MONA OFFSHORE WIND PROJECT

Change Request Consultation Feedback Response

Application Reference: EN010137

Document Reference: S_D6_2

Figure 2: Passing Locations

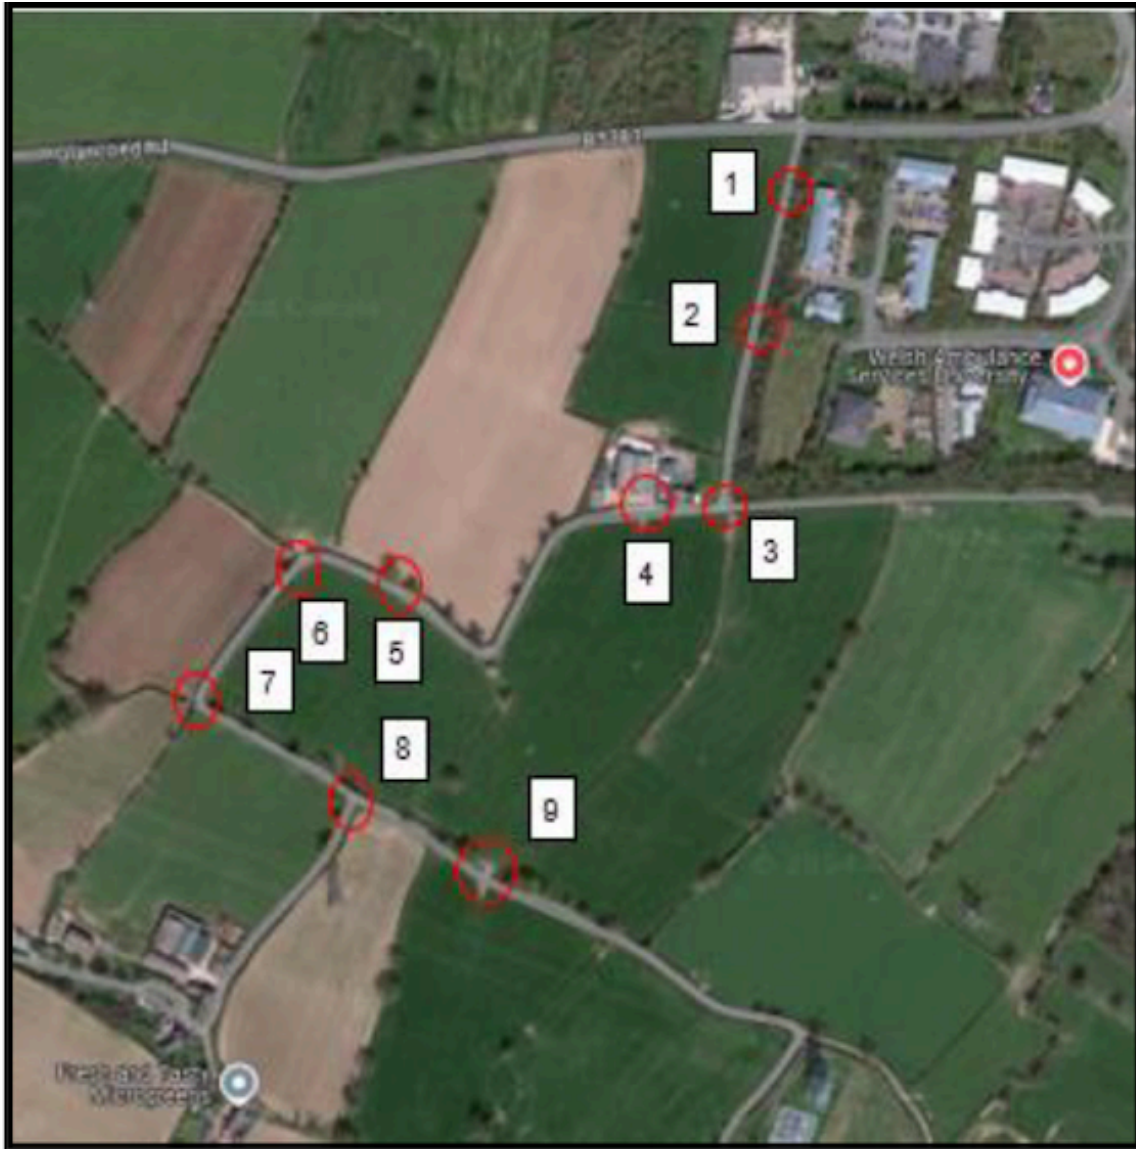
16. **Passing Places.** The availability of passing places on a road of this nature is critical. The Appendix (1.2.2.3) states that there are "approximately nine", as per the Applicant's own Figure 2 reproduced here.

As is shown below, this is grossly misleading, and it can only be assumed that it was produced from a desk-top exercise rather than any site visit or familiarity with the actual road itself. It will be noted that only three of the "Passing Points" identified by the Applicant are within that section of road where the ninety-degree bends have to be negotiated, and one of these ("Passing Point 7") cannot realistically be taken into consideration. Below are photographs of each of the nine locations shown in the Applicant's Figure 2. It hardly seems necessary to further point out the limitations of these "Passing Points", but perhaps 7 and 9 merit particular attention. (It is acknowledged that these photographs were taken in particularly inclement weather conditions due to the necessity to meet the ExA's Deadline 5)

The Applicant notes the response and refers to Appendix 1 to Annex 1 of the Change Request Report (CR1-030) which provides an assessment of the road in terms of its geometries, layout, passing locations, vehicle movements and road safety and did not identify any current road safety issues along the road or at its junction with the B5381.

Appendix 1 to Annex 1 of the Change Request Report (CR1-030) refers to these as 'passing locations' rather than passing places so as not to seek to define these as formal (sometimes signposted) passing places that accord with highway design standards and being constructed to any recognisable geometry or layout. Indeed, by referring to these as 'passing locations', it recognises that they are commensurate with rural single track roads of variable geometries and layout but nonetheless, provide the ability for oncoming vehicles

to pass one-another, as is depicted from the photographs contained within the response.

The Applicant has updated the Outline Construction Traffic Management Plan (J26.13 F04) to include additional measures to ensure the safe use of the B5381 to Access AC-T1 (Change Request 1a). These updates have been agreed as suitable by the relevant local highway authority (CR1-046).
